Application Reference: 6/2020/2211/EIA

Proposal: Request for a Scoping Opinion at the North Side of the Former Shredded Wheat Factory, Bridge Road, WGC.

Location: Former Shredded Wheat Factory Bridge Road Welwyn Garden City AL8 6UN

This letter documents the findings of a review of the Shredded Wheat Factory (North Side) Environmental Impact Assessment (EIA) Scoping Report (the 'EIA Scoping Report'), prepared by Entran Limited (Planning Ref. 6/2020/2211/EIA dated 20 August 2020). In formulating this Scoping Opinion the following has been taken into account:

Figure 2.1: Site Boundary

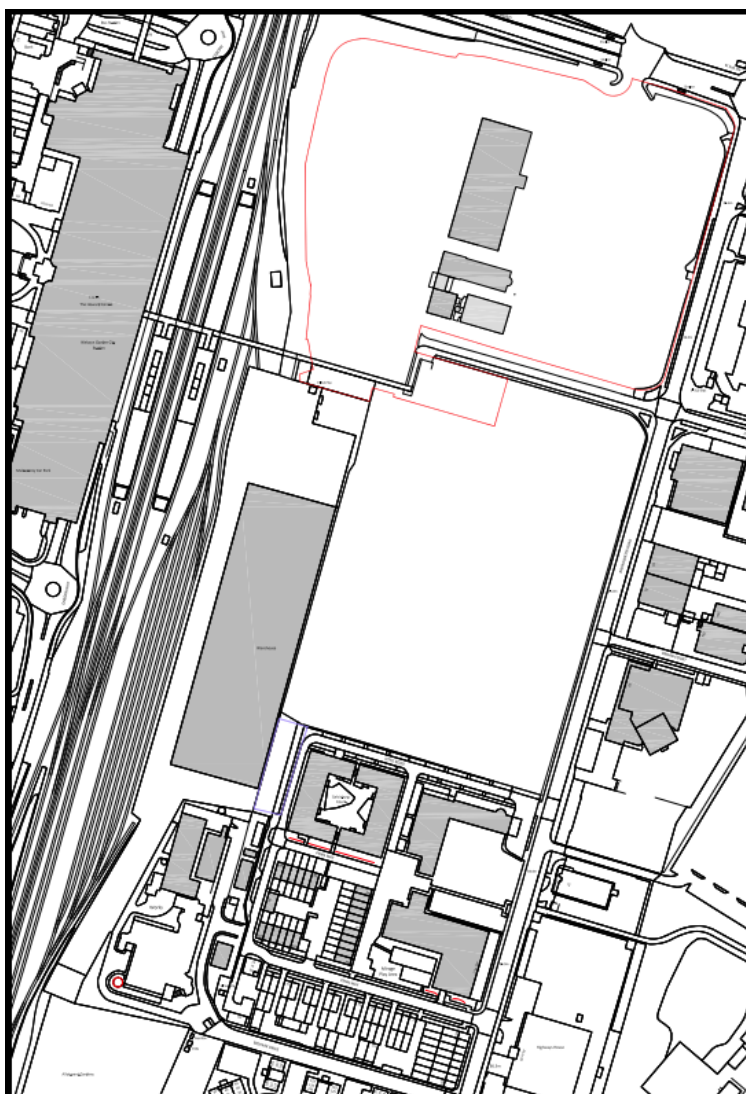
EIA Regulations requirement	Requirement met in the EIA Scoping Report?
i) a plan sufficient to identify the land;	Yes. A plan is provided as Figure 1 which identifies the site location. However, it is noted that this plan is of poor quality, whereby road names / building names / identifying features are illegible, nor is it at a scale which is suitable to

identify the surrounding area. There is no key, scale or north arrow; it is only when reading paragraph 2.2 that it is made clear that Figure 1 shows the planning application boundary.
ii) a brief description of the nature and purpose of the development, including its location and technical capacity;	Yes. A description of the location of the Site and the surrounding area is provided within Section 2 of the Scoping Report. This is considered to meet the requirements of the EIA Regulations. No. A very brief description of the Proposed Development is provided within Section 3 of the Scoping Report; however, it lacks any detail other than approximate numbers of dwellings. In order to scope the EIA to be determined it would be expected that some description of the physical scale of the Proposed Development, such as maximum building heights / storeys should be set out. Section 1 refers to the extant permissions which apply to the site and wider site, but it is not clear which elements of these permissions will be extinguished as a result of the Proposed Development.

The description of the site and its surrounding area, within Section 2 of the Scoping Report, is considered adequate for the purpose of EIA Scoping. However, a greater level of detail will be required within the forthcoming ES. It is recommended that the ES is supported by plans of a suitable scale and quality to identify the site and wider context of the surrounding area.
